Application No: A/48/22/RES
Site Address: Land off Arundel Road Angmering BN16 4ET
Description of works: Approval of reserved matters following A/122/19/OUT and varied by A/207/21/PL pertaining to the layout, scale, appearance and landscaping for 160 No dwellings. This application is a Departure from the Development Plan and is in CIL Zone 3 (Zero Rated) as new dwellings.

Thank you for your internet representation made on 14th September 2022 which has been recorded as no objection with the comments as follows:

Timber / render gables

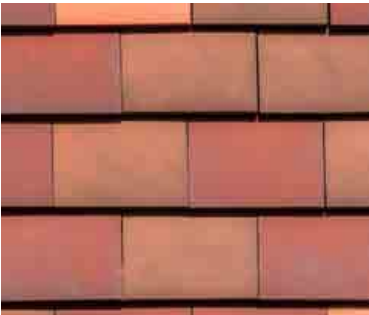
Street Scene D-D plot 123 & 125 the white and black timber/render gables does not reflect anything in Angmering outside of the conservation area
